APPLICATION FOR EXEMPTION FROM SITE PLAN REVIEW

Consultant/Agent/Phone Number Joe Sanders 735-1074 Address of Proposed Site Rear of 410 Fore St (wharf)  
Wharf/Dang

Description of Proposed Development: ATM ON BRICK FACADE OF BUILDING  
(see photo attached)

SITE PLAN 1"=10'-0"

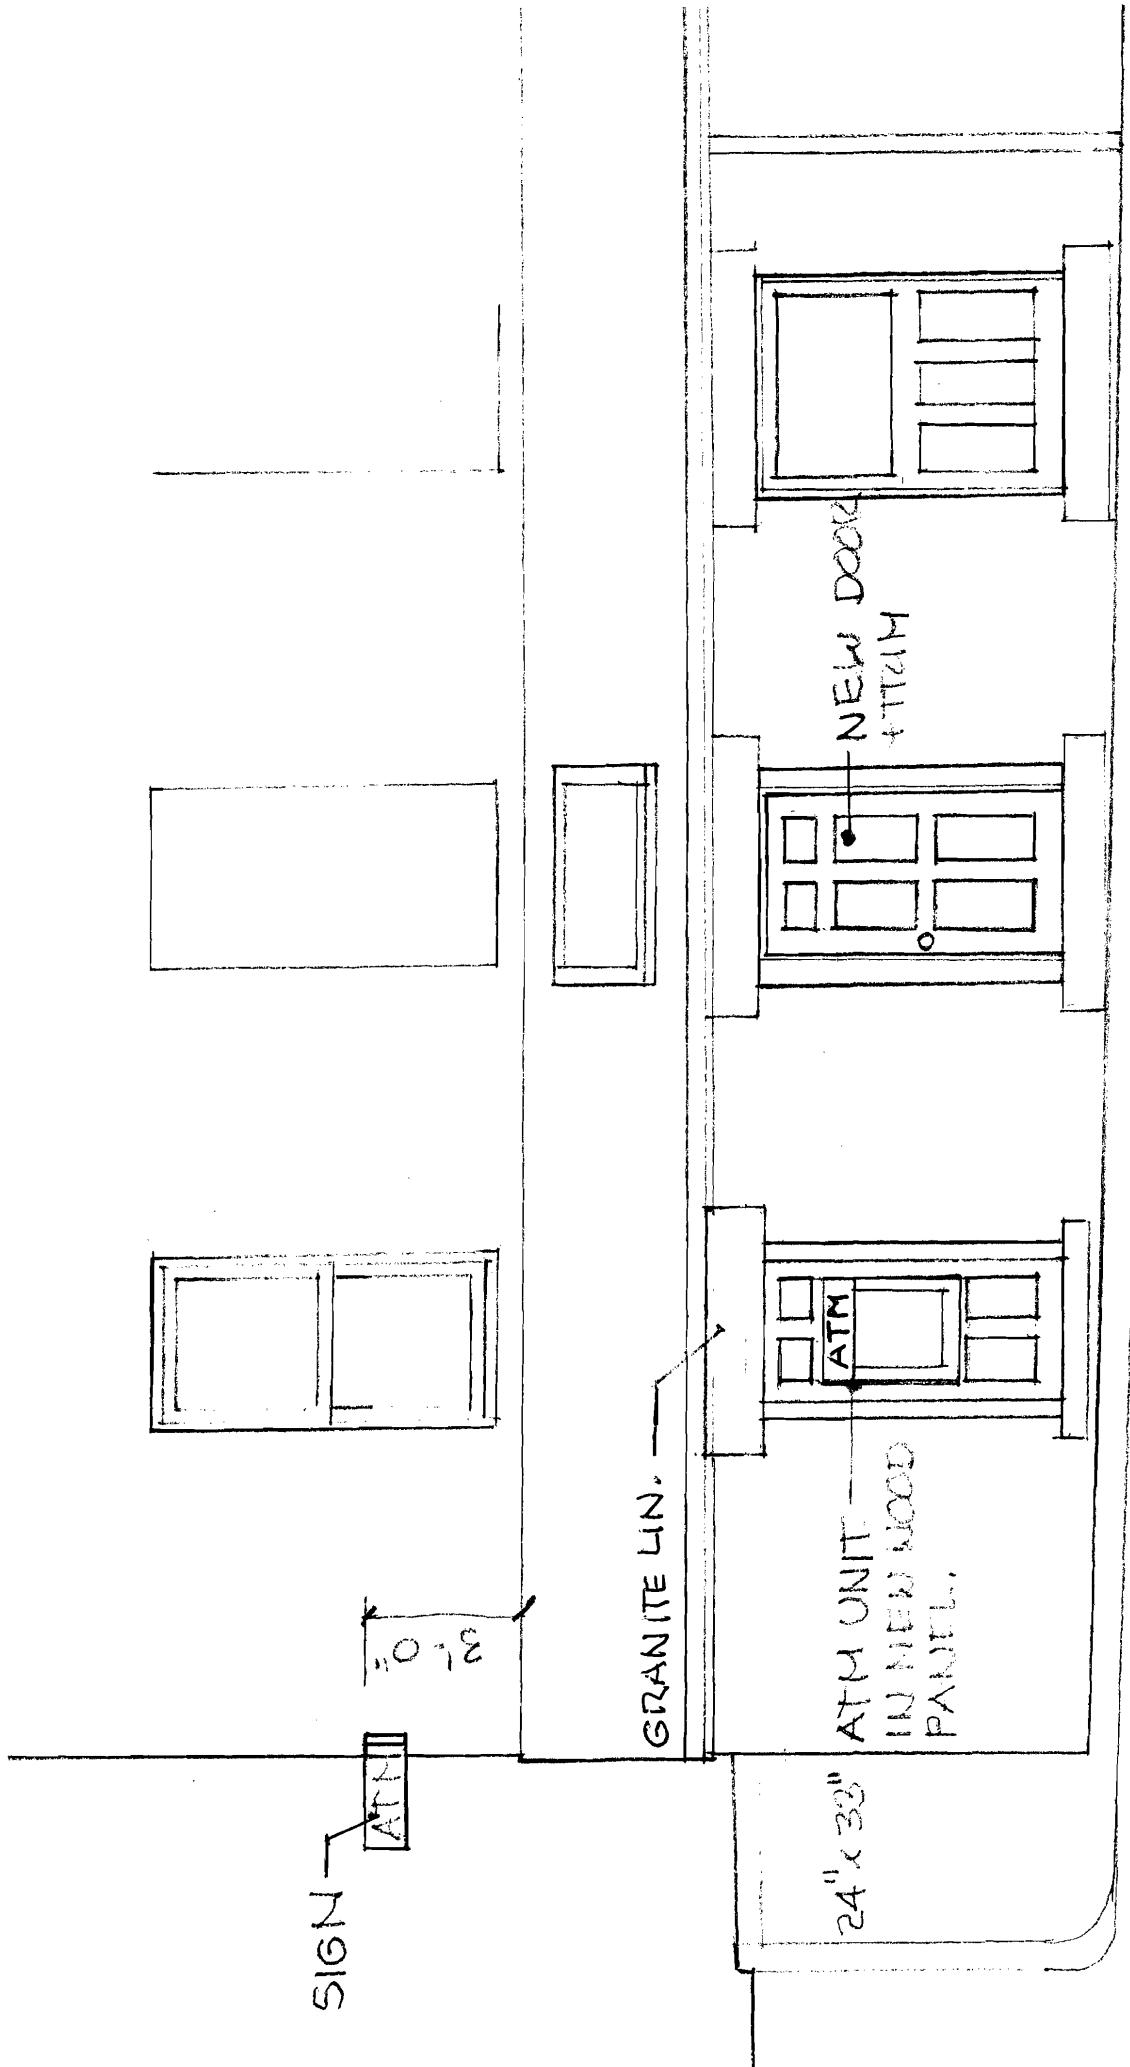
*The exemption is a general subject to the approval of the Board and the installation of two bollards in the sidewalk to prevent drive-ups. Review*
